Our Ref: 20048269
PINS Ref: EN010119
Date: 4 March 2025
Telephone: 03330 322546

Planning Act 2008 – Application by North Falls Offshore Wind Farm Limited for an Order Granting Development Consent for the North Falls Offshore Windfarm (EN010119)

1. Highways**5.19 Temporary Traffic Regulation Order Plan (Rev 1) [REP1-010]**

**Temporary Traffic Regulation Order Plan -  
Sheet 9 of 16**

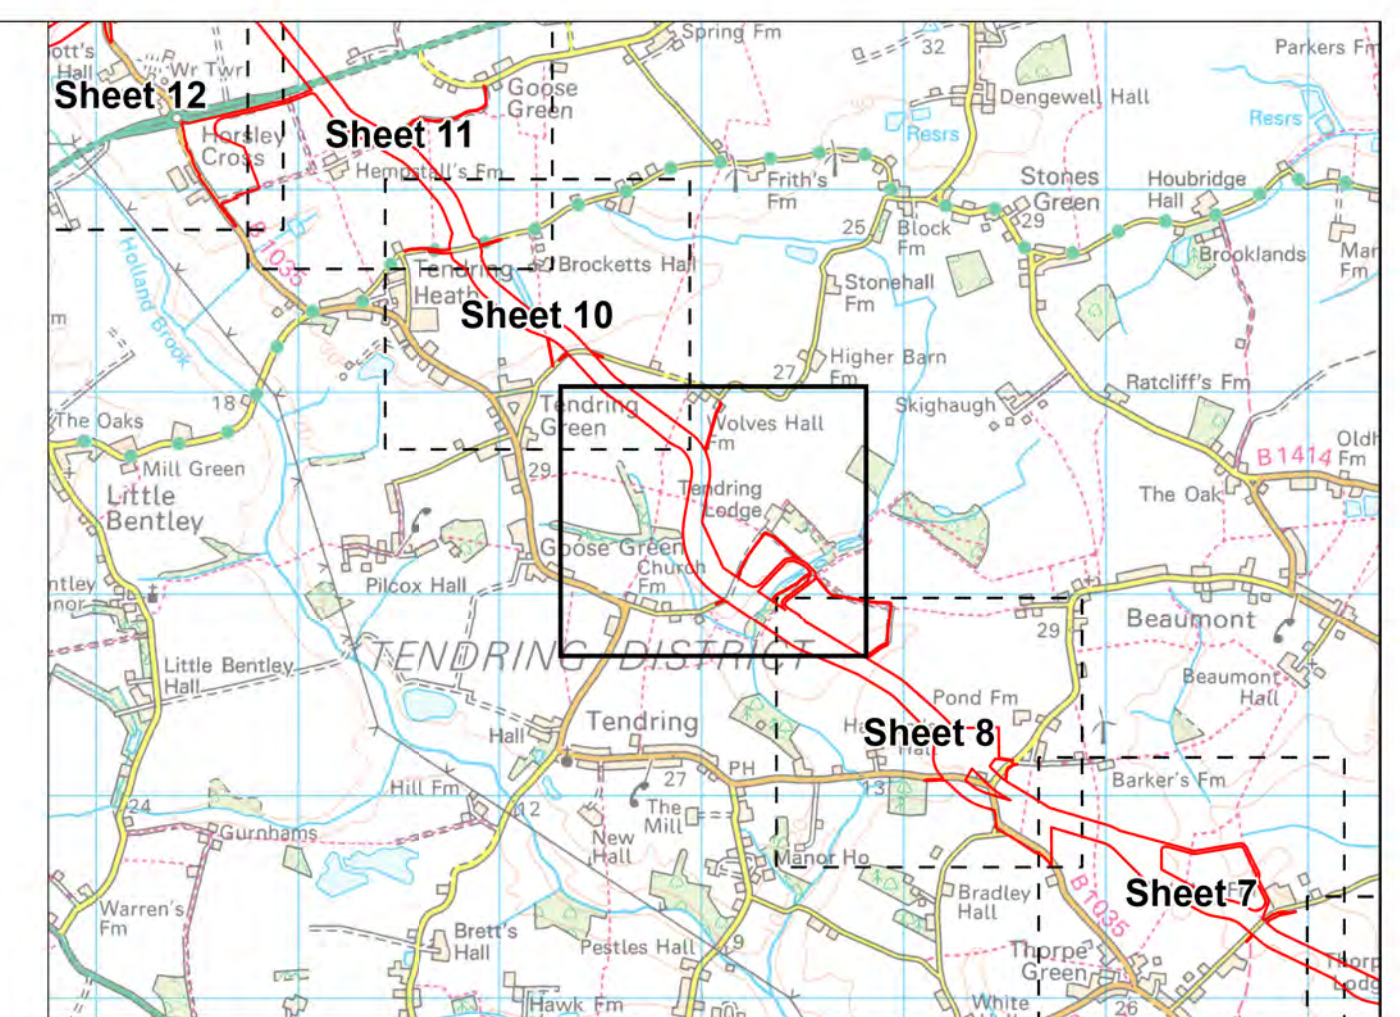
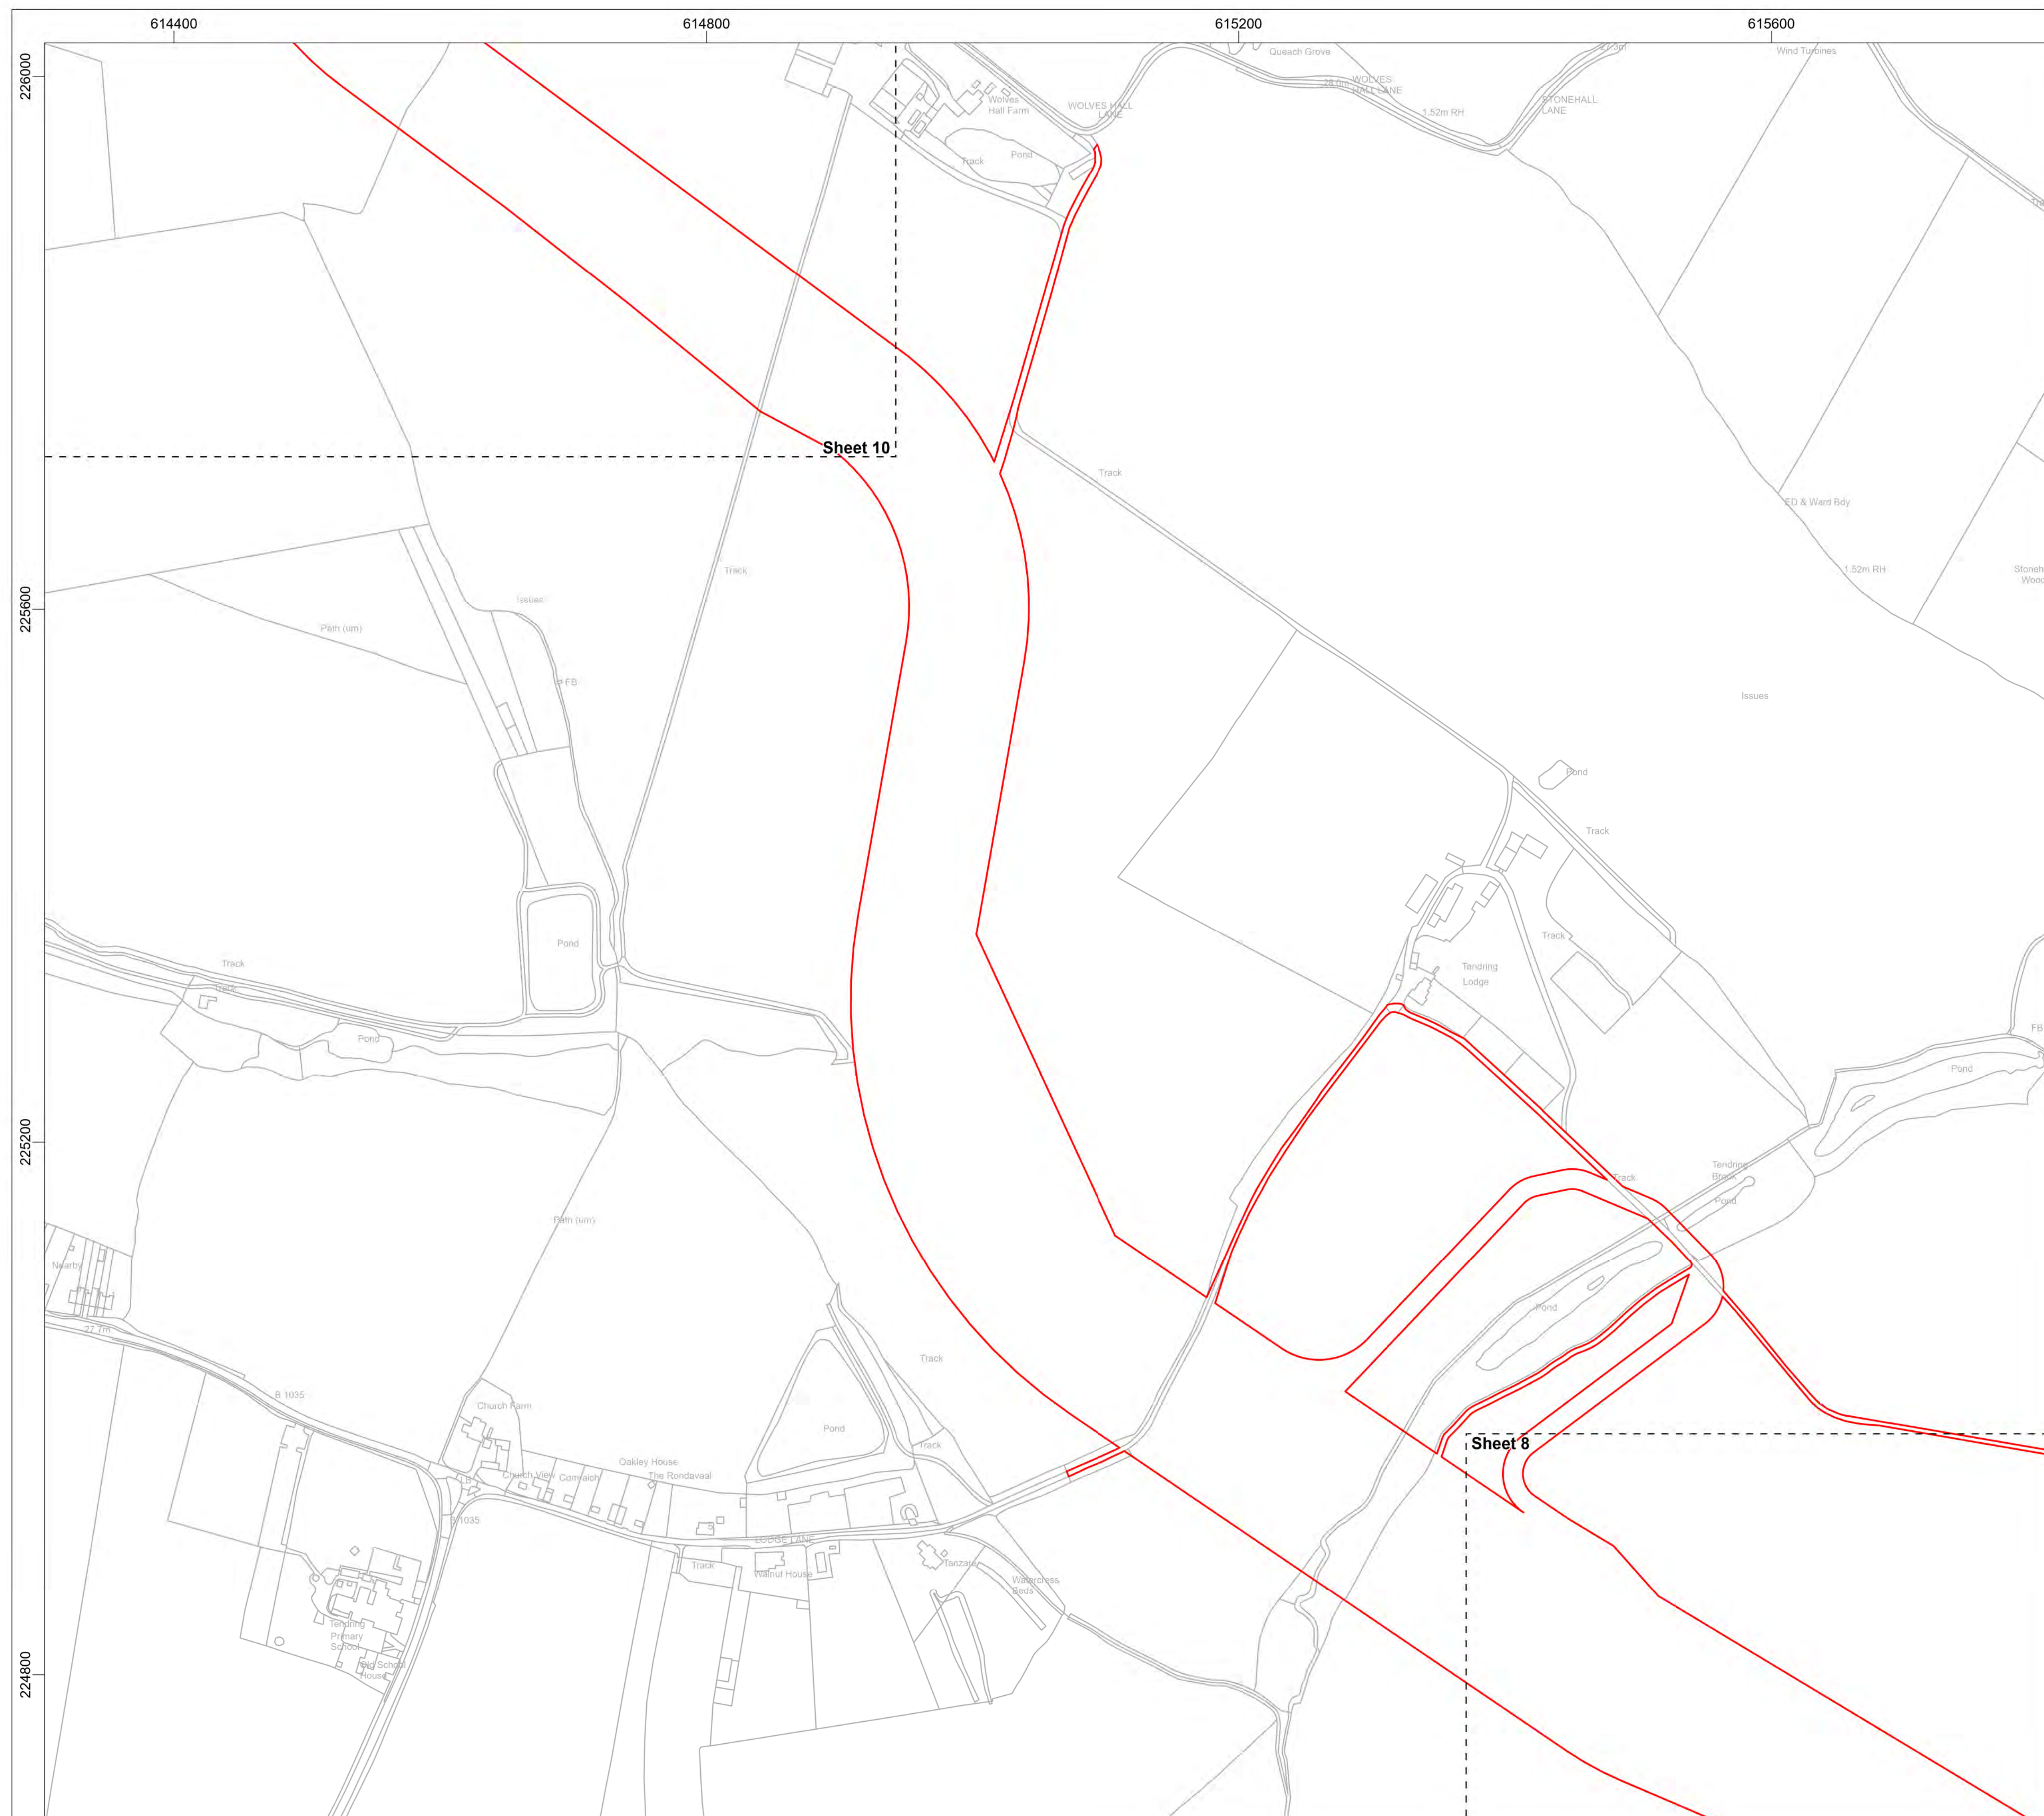
Page 12 (sheet 9 of 16):

The plan for Footpaths 3 and 8 Tendring shows an out-of-date alignment and number for Footpath 3.

This footpath will still require a temporary closure to facilitate their works, but in a different location to that shown on their plan and a different path number too, so an amended plan will be required for the final PAMP. No other discrepancies have been found between their plans and the PROW mapping.
